**MIKE CAUSEY**  
INSURANCE COMMISSIONER & STATE FIRE MARSHAL

April 4, 2023

**RE: The Springs of Ballentine  
Hectors Creek, NC – Harnett County**

Updated construction documents received on 3-24-2023 relative to the above-named project have been reviewed for a schematic design in general compliance with the 2018 edition of the North Carolina State Building Code with the following comments. This review does not replace the plan review of the local Authority Having Jurisdiction (AHJ). This review is in addition to the plan review of the local AHJ. This plan review may contain comments related to Accessibility, Plumbing, Mechanical, Electrical, and Fire Codes.

## LIFE SAFETY PLAN

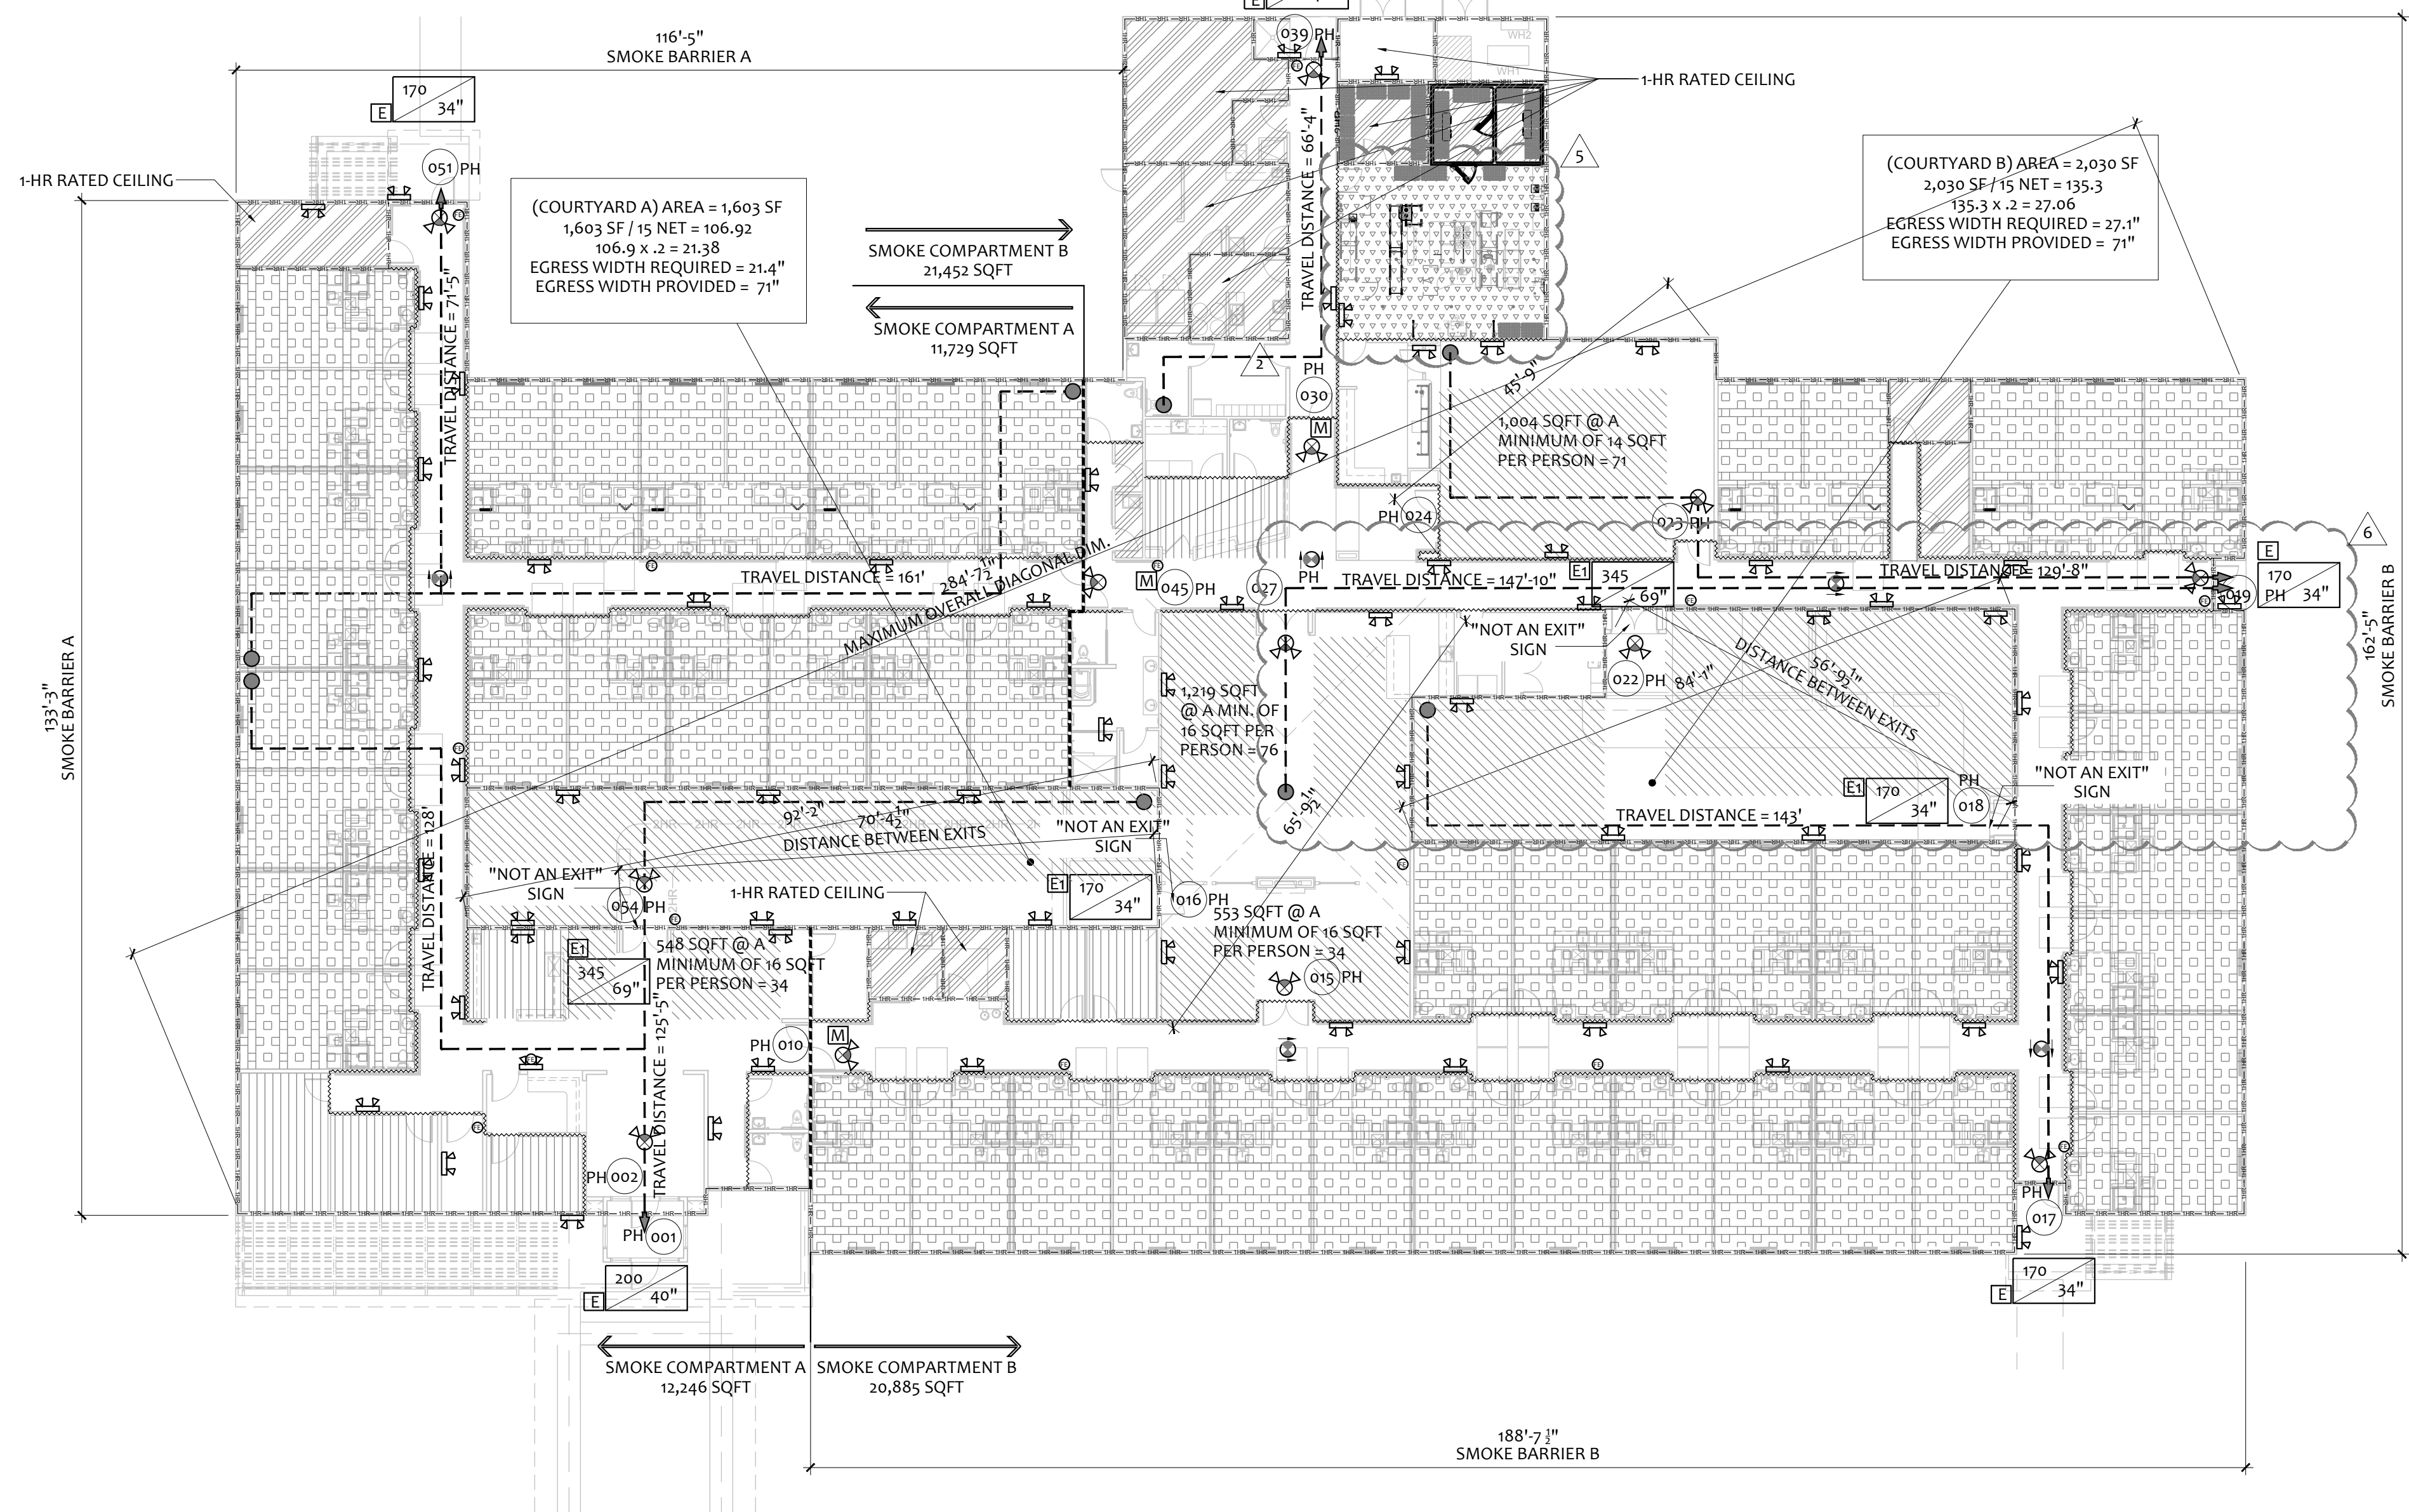
6. Page A002 - Interior and exterior emergency lights shall be shown on the Life Safety Plan. Exterior emergency lights are missing from east and north exterior exit doors as well as all the electrical rooms including rooms 155 and 193.

10. Pages A002 and A701 – Doors 018 and 054 have panic hardware assigned to them on the Life Safety sheet. Please add the “3” and/or “4” in Comments column to identify hardware sets. Also, Door 054 has no hardware set assigned to it on Door Schedule.

Scale:	AS NOTED
Date:	JAN. 2022
Drawn By:	DJB
Checked By:	ZHG
Job No.:	E-1657
Sheet No.:	C-3

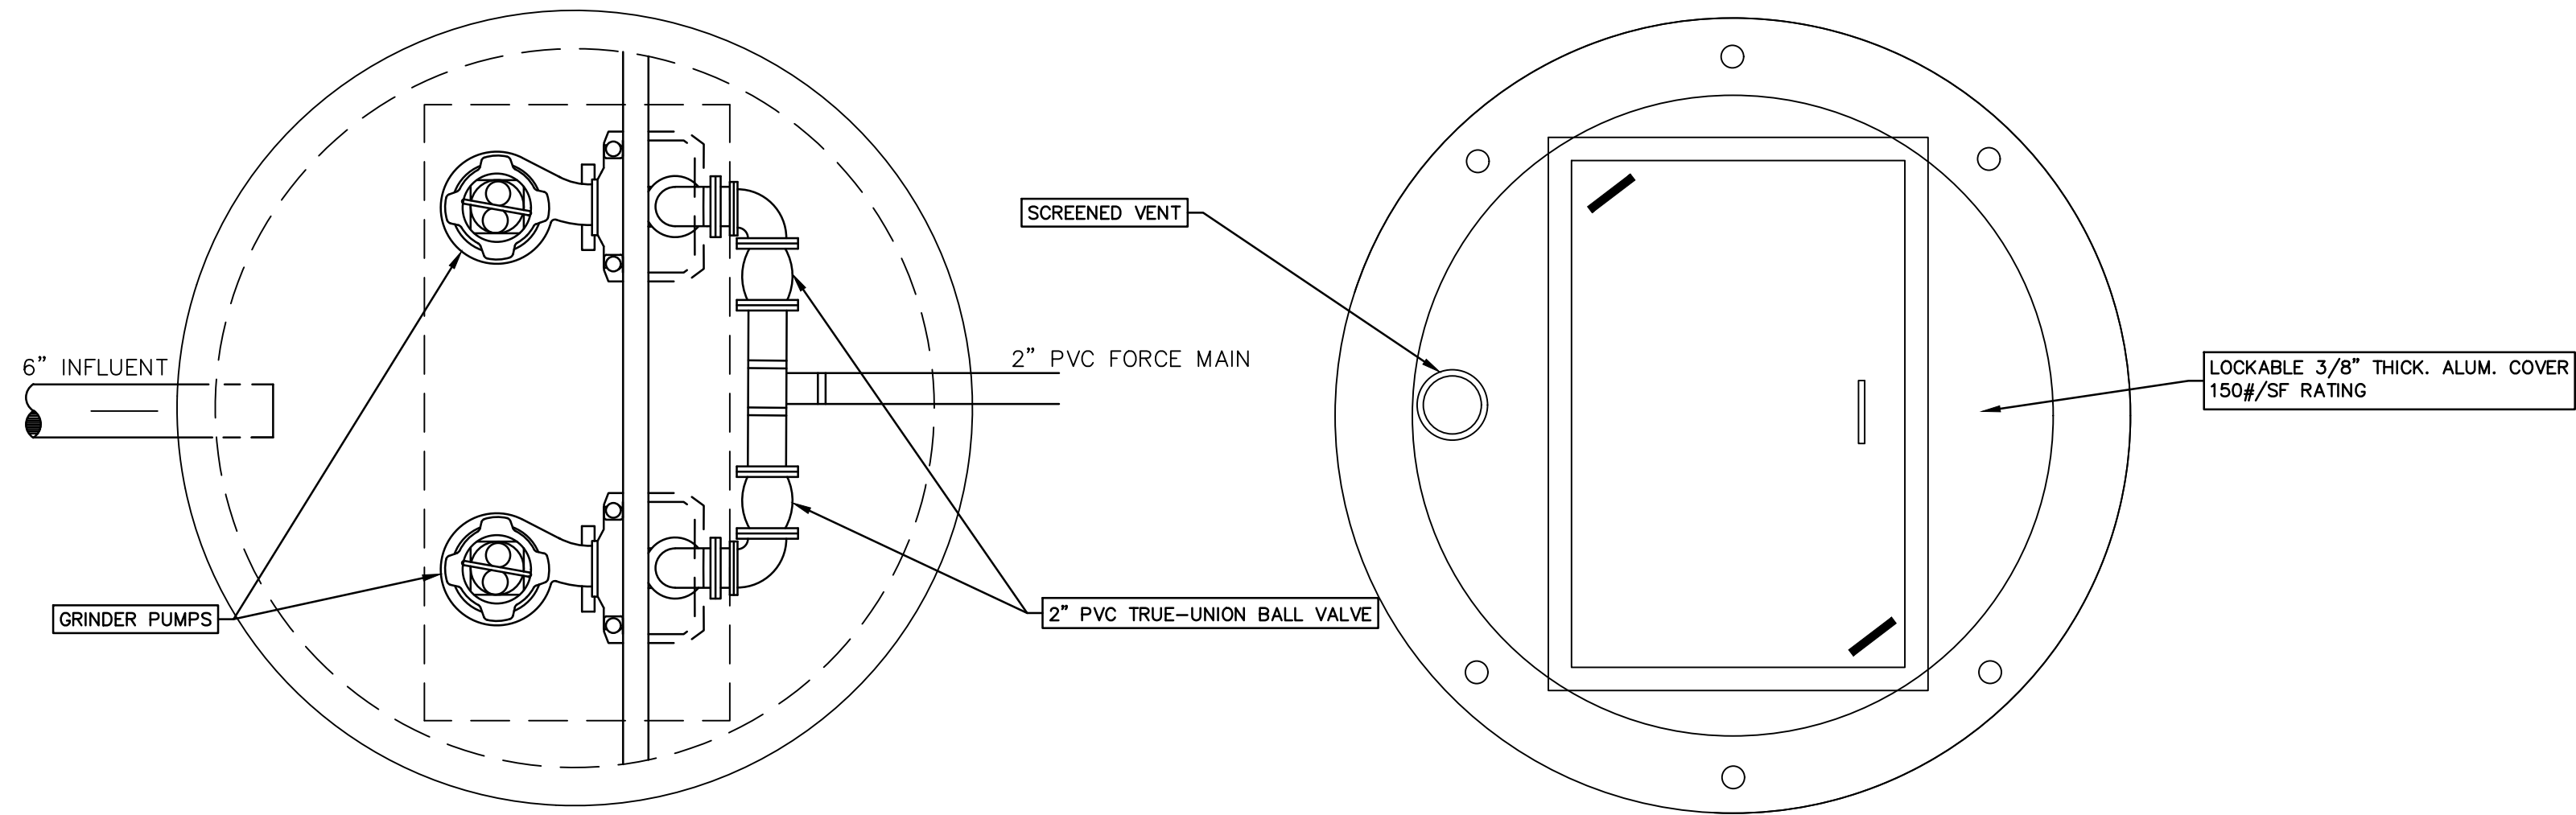
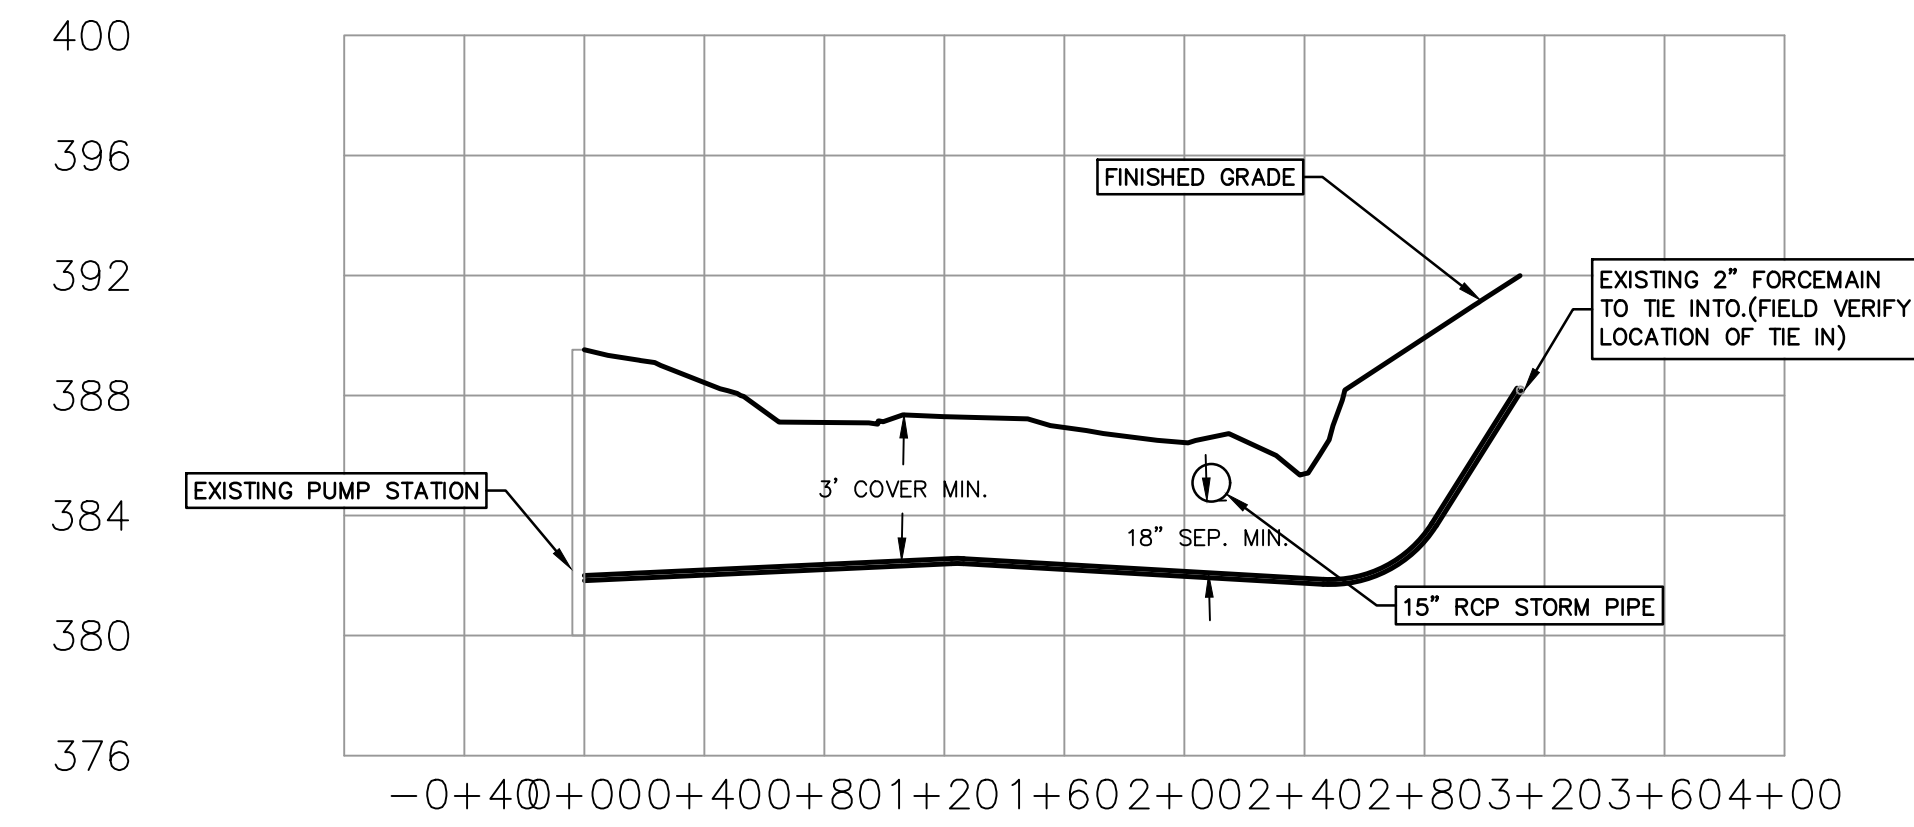
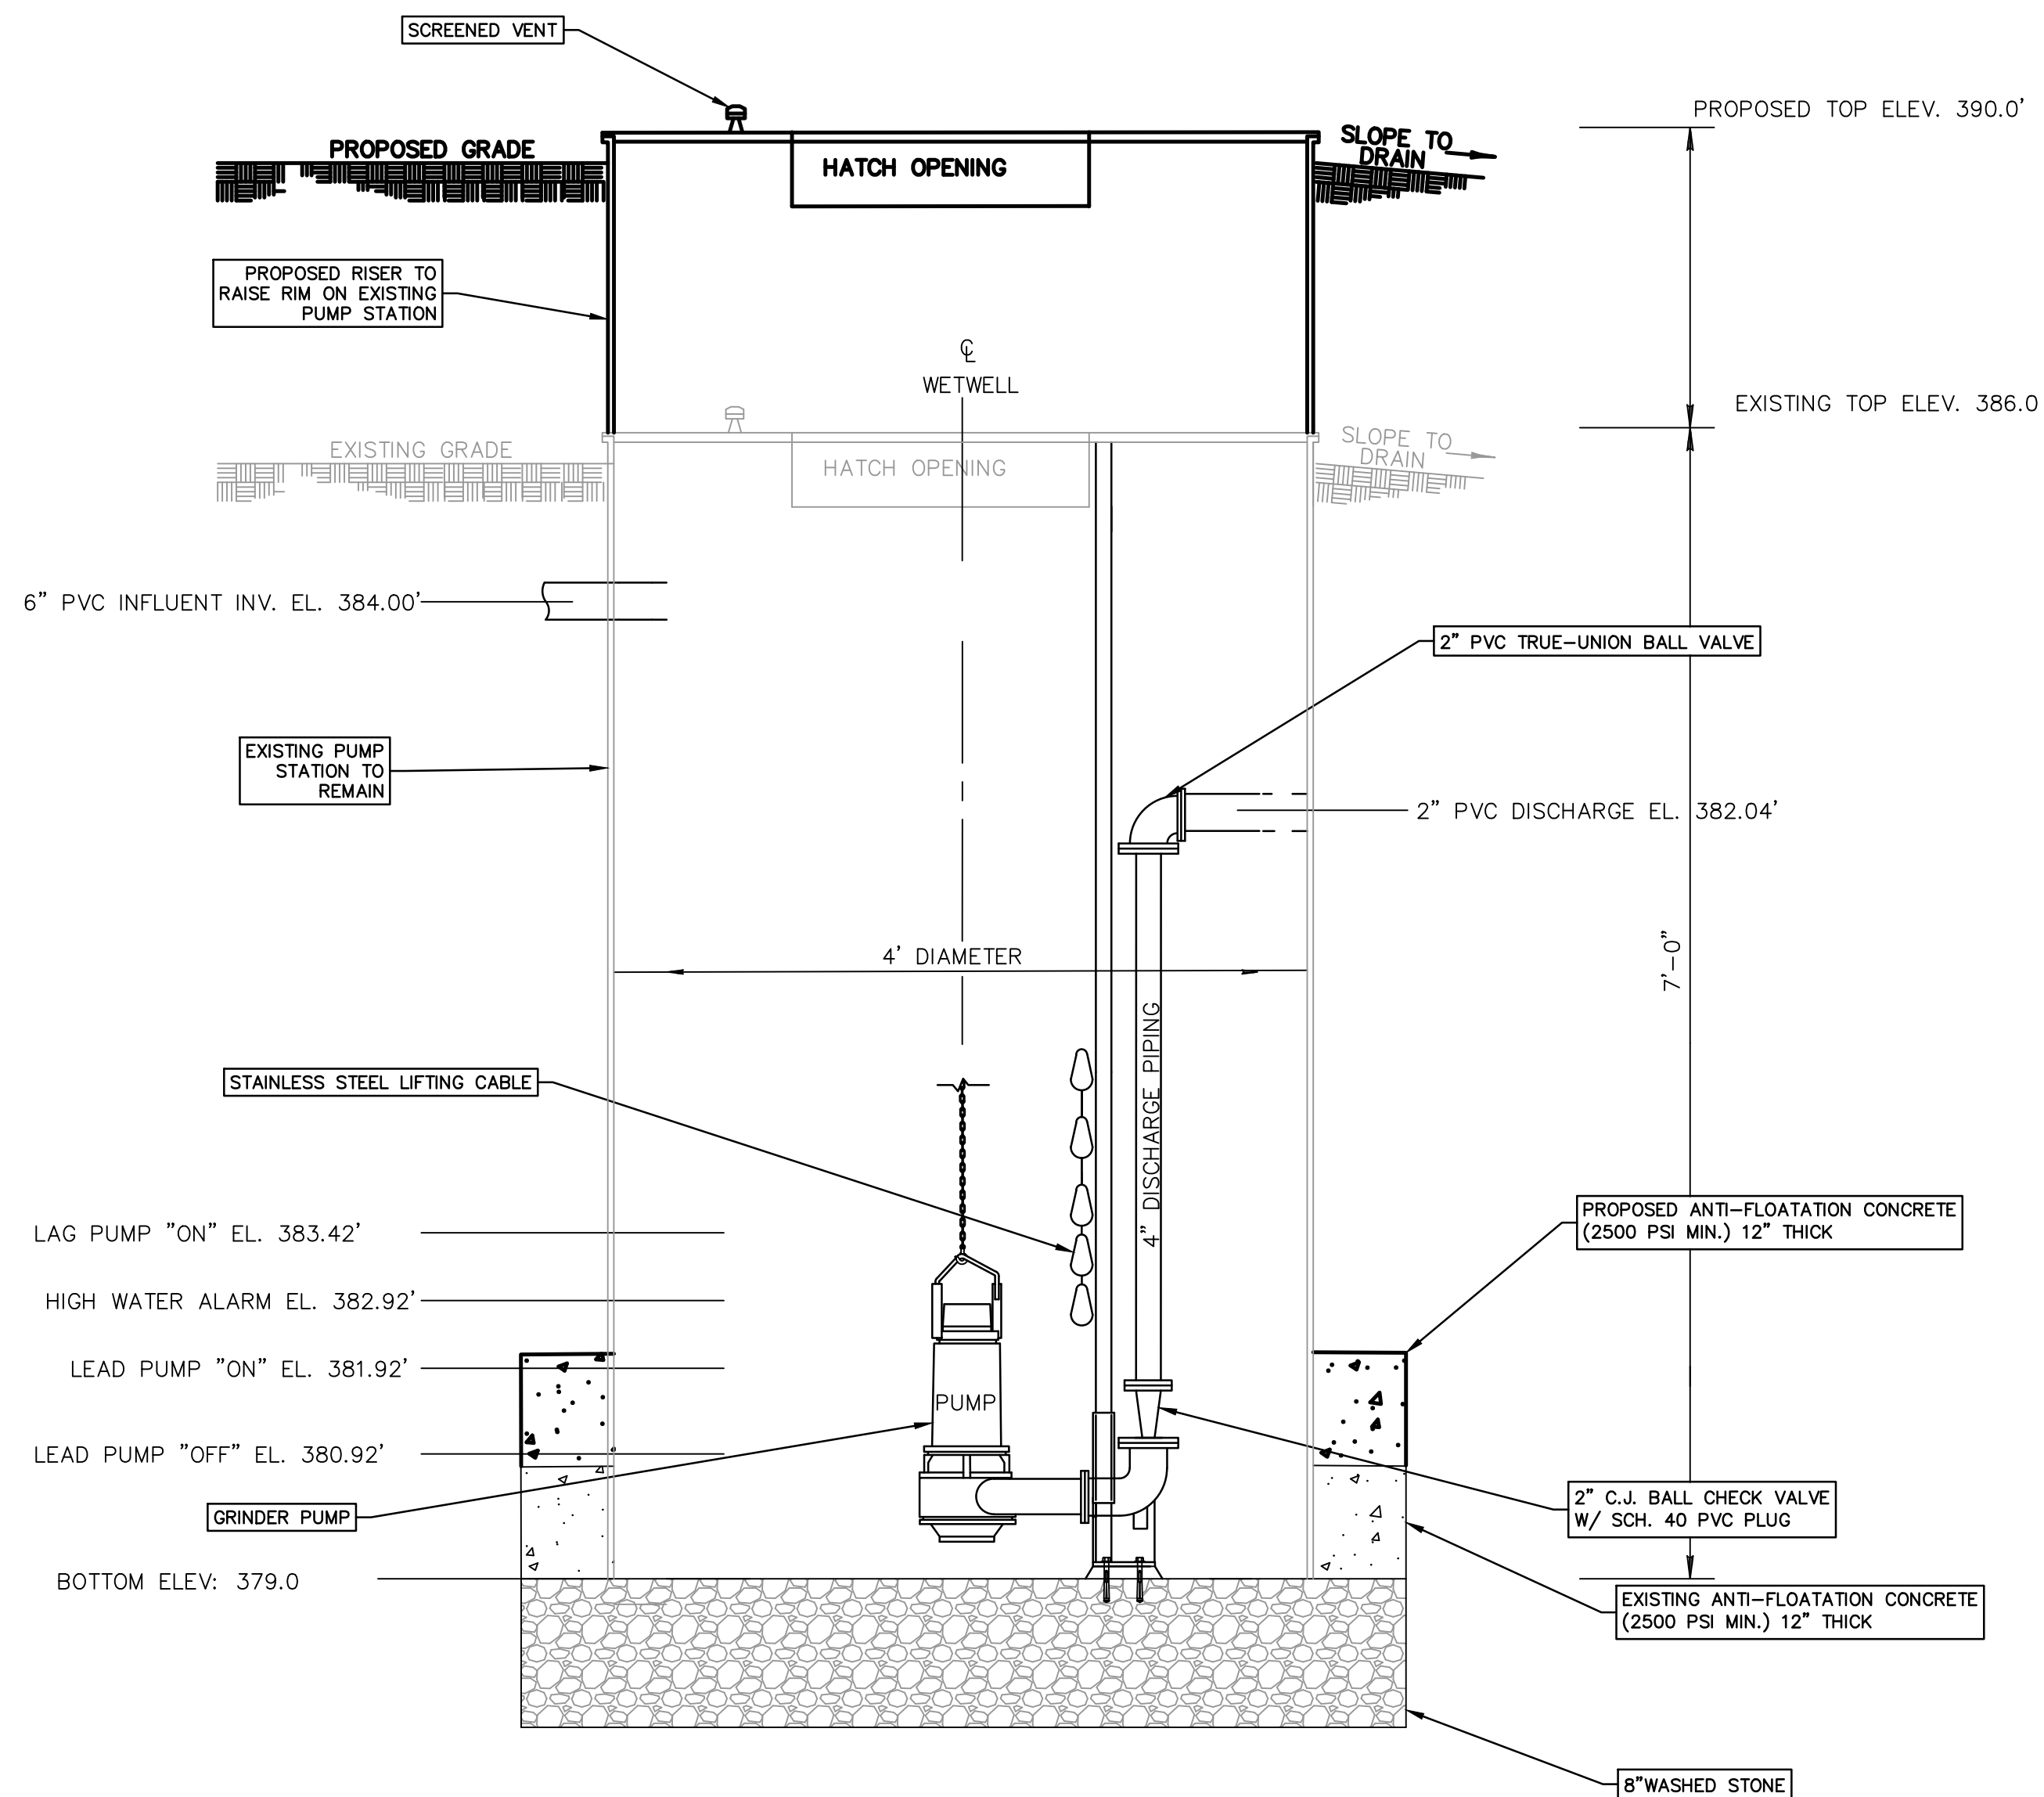
- Building Code, Section 1106.5. This shall be located on the shortest accessible route of travel from accessible parking to the accessible entrance. Impacts pages C-3, C-6 – C-9.
